From: James Russell
Sent: 18 July 2013 17:24
To: Claire Booth
Subject: Planning Application 3/2013/0539/P QEII Playing Fields, Whalley

Further to our joint site visit on Thursday 18th July 2013, I would make the following comments in regard to this application;

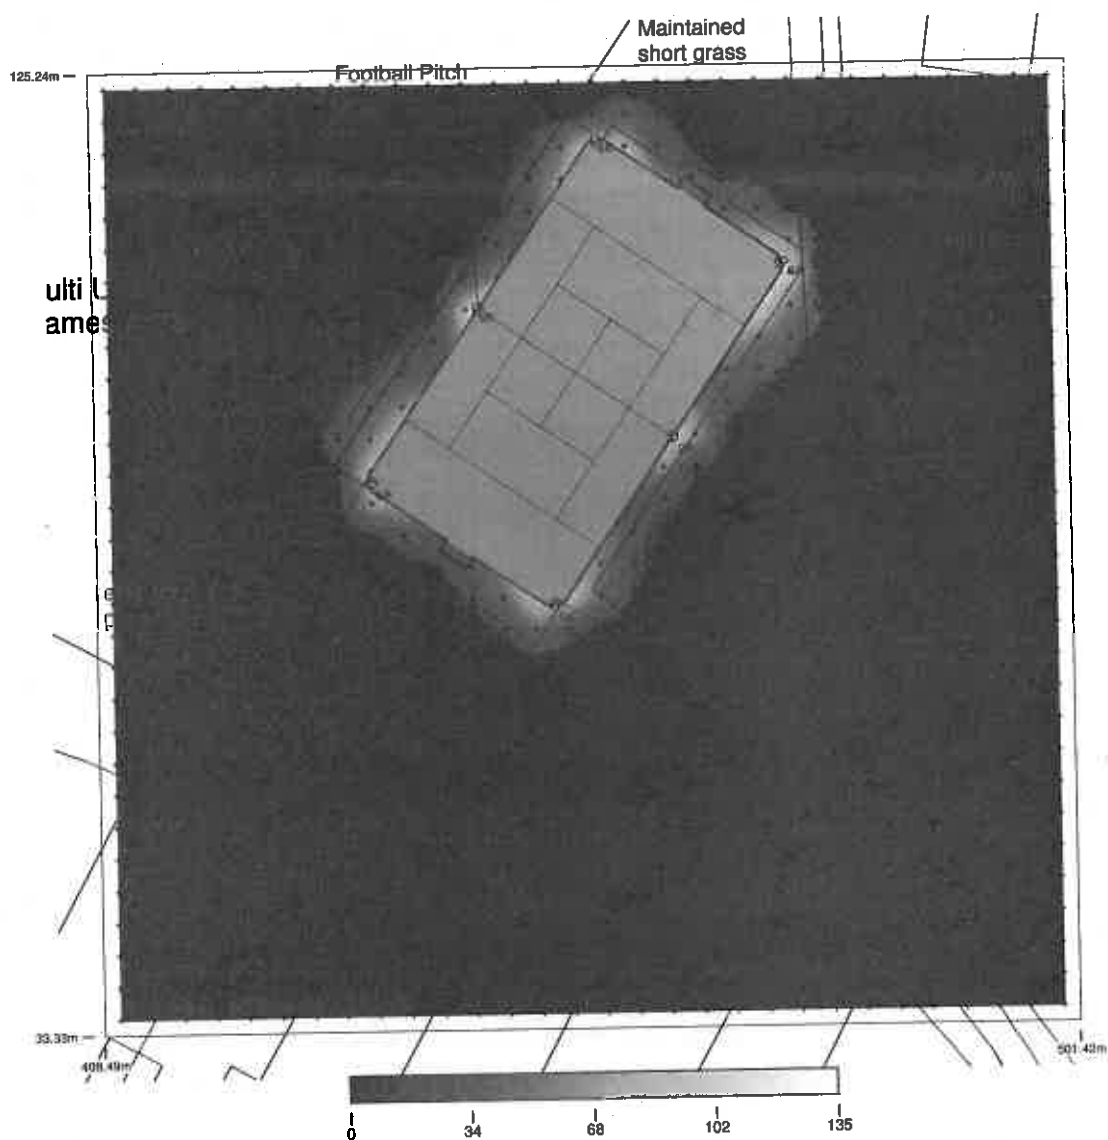
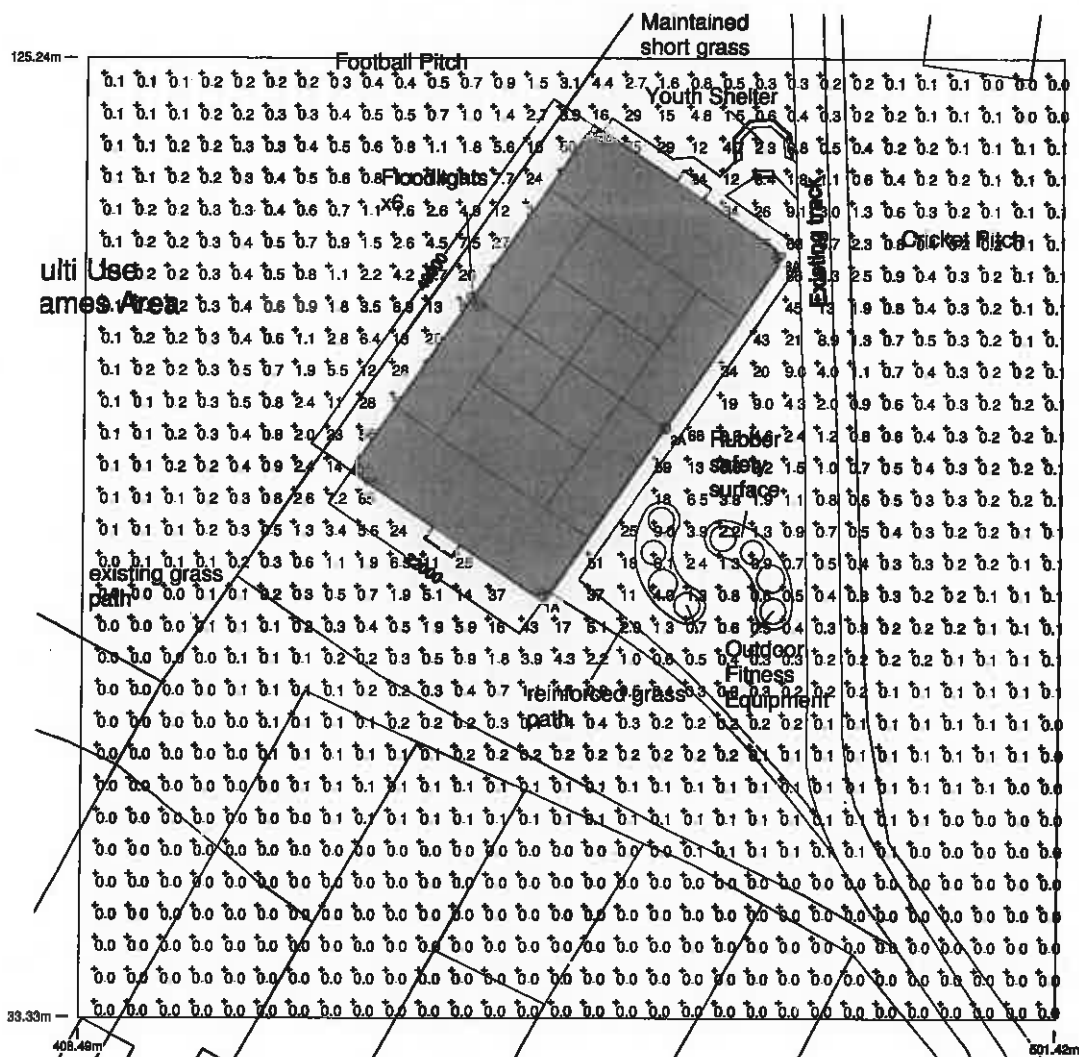
In addition, the floodlighting footprint indicates significant light spillage around the pitch and would appear not to be in line with BS/EN recommended lighting standards contained in Lighting Guide 4: Sports Lighting 2006 for a floodlighting in a rural location - 0.5 lux.

In my experience, the all weather pitch may also result in considerable glow reflected from the synthetic surface and needs to be considered accordingly

I would strongly recommend that the applicant be approached to relocate the development to a more suitable and remote position on the site and that further consideration and information will be required concerning; hours of use, lighting design to meet relevant rural zone lighting, pitch materials to prevent potential light pollution and acoustic measures.

COMMUNITY BUILDING			
Project		Whalley QE2 Trust	
Drawing		MUGA Plan	
Date		05/14	
Scale		1/100

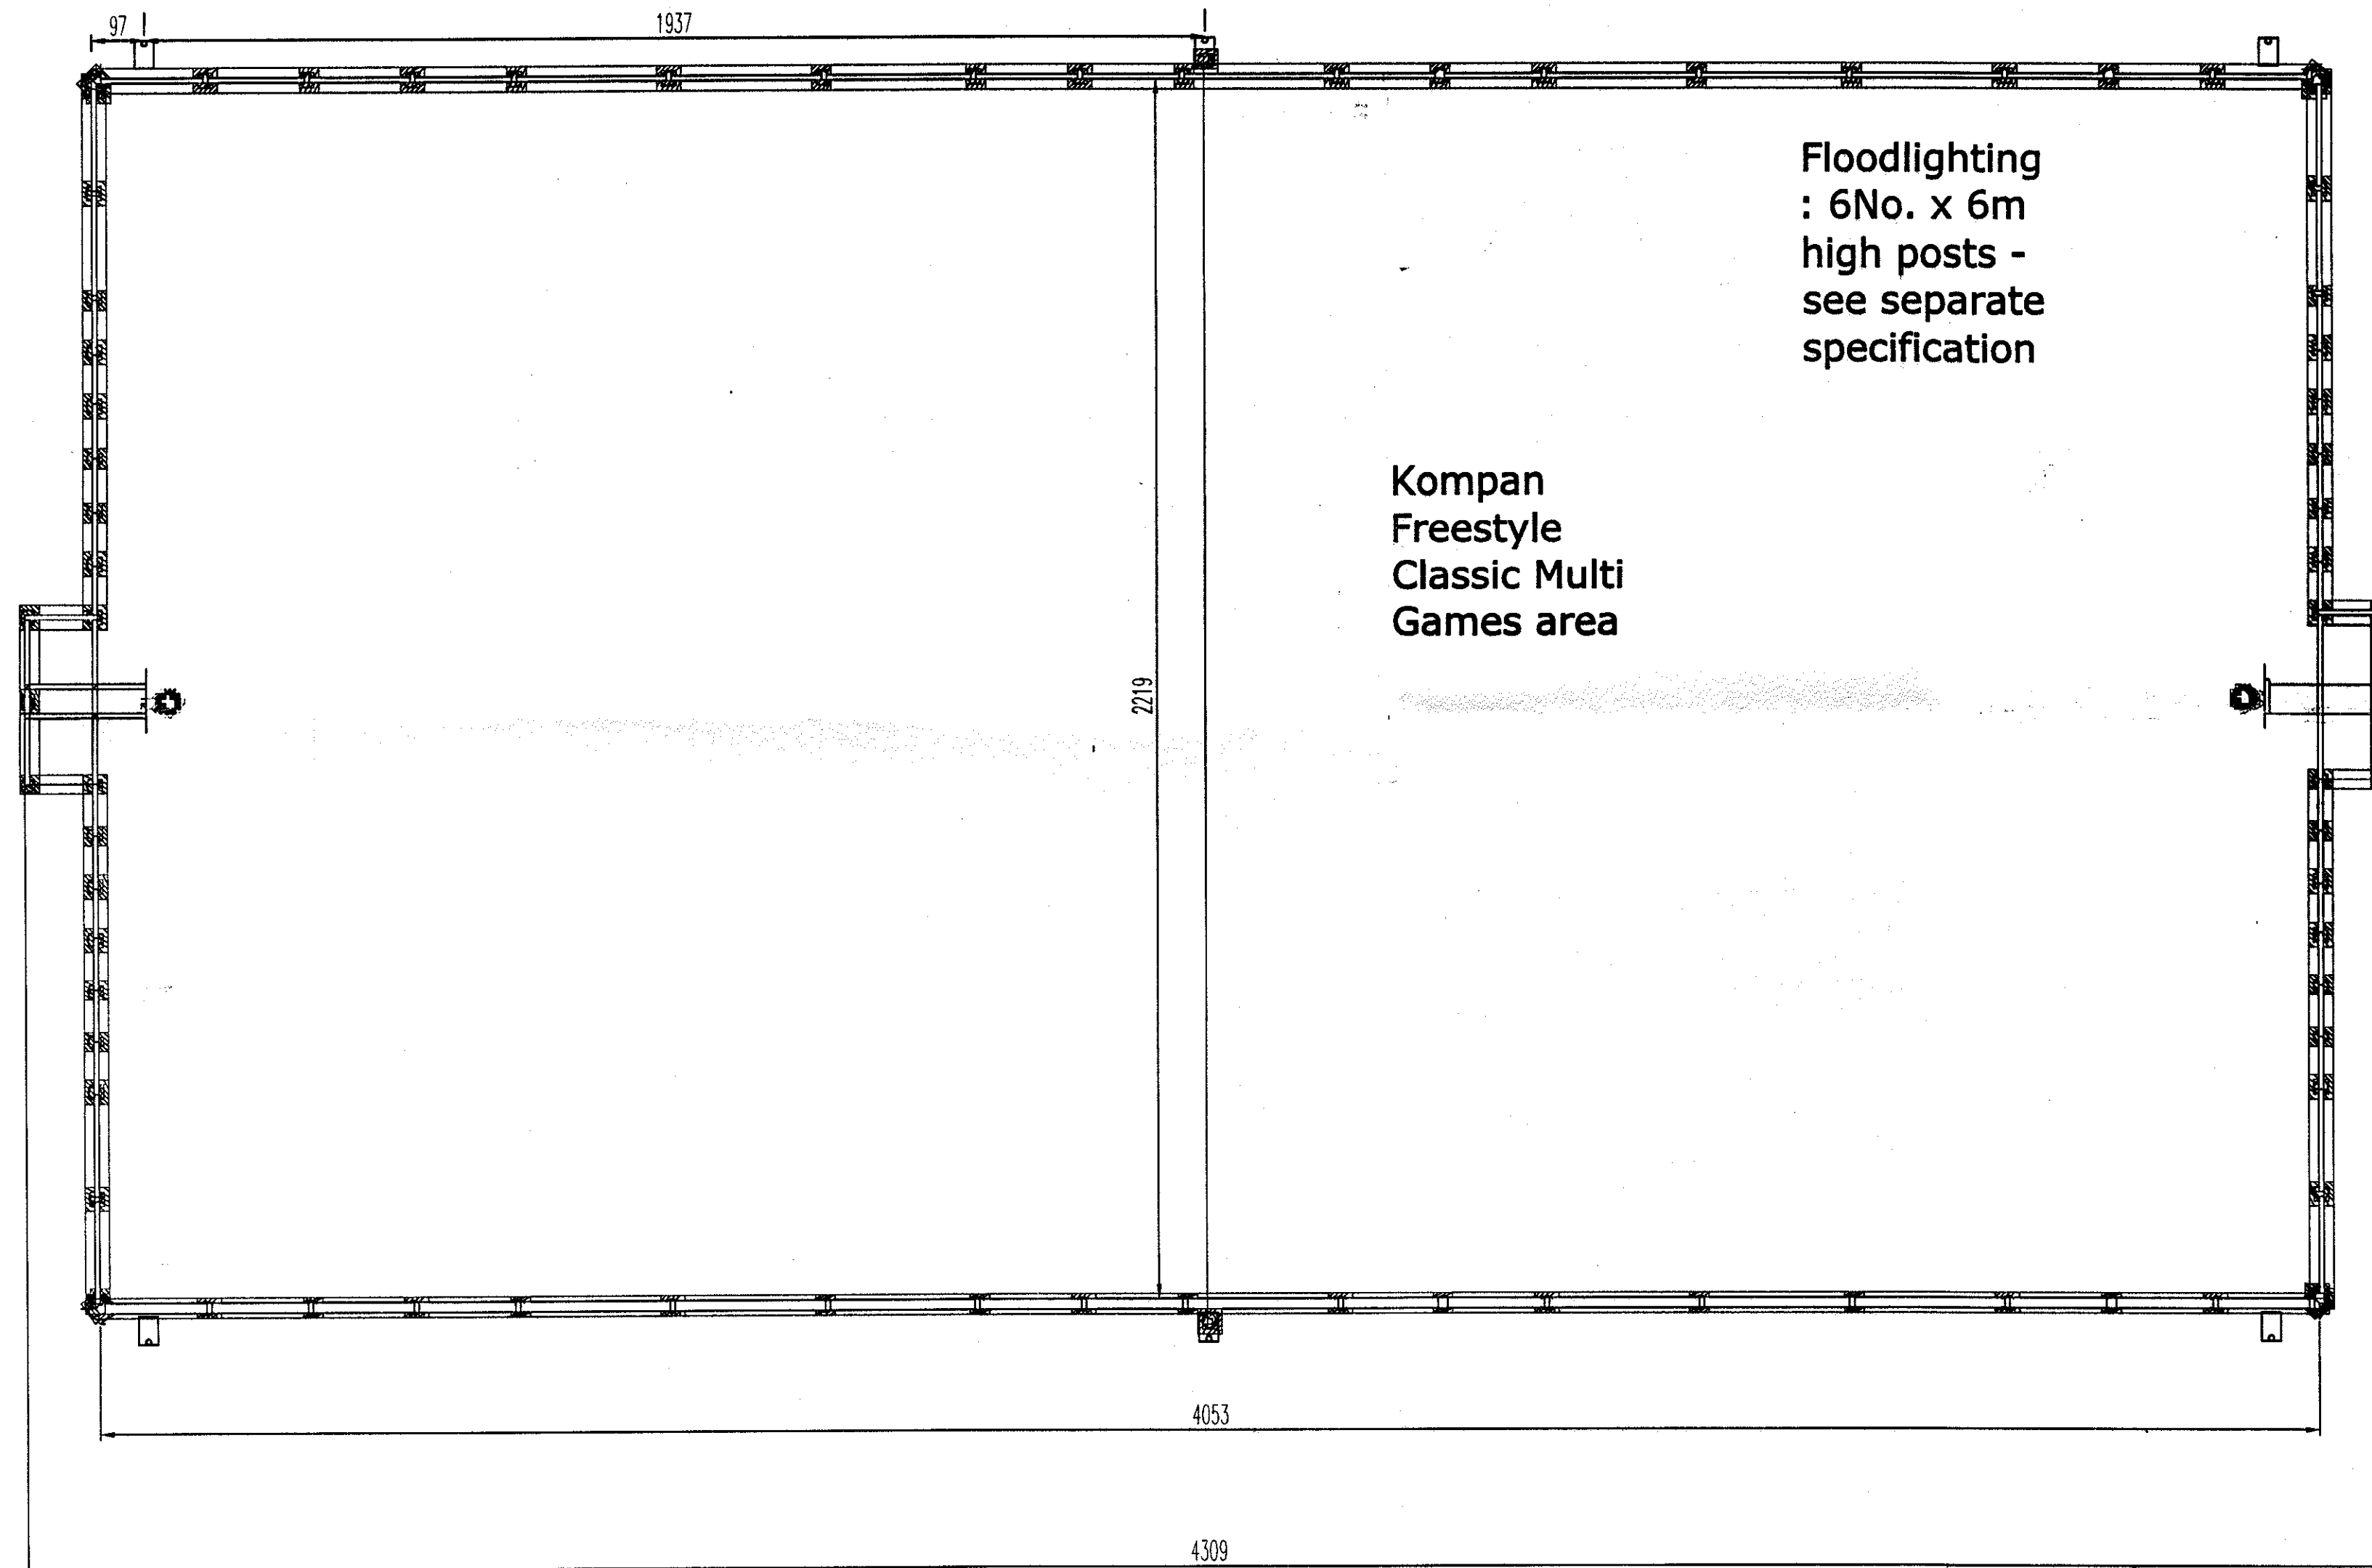
The proposed position of the community floodlit 'all weather' pitch etc is likely to result in considerable noise and potentially light pollution to nearby neighbouring residential properties.

In particular the application suggests no restriction on 'hours of use' of the facilities.

Noise from the playing of sports is likely to be considerable with the pitch having no acoustic reduction measures and being in close proximity of neighbours.
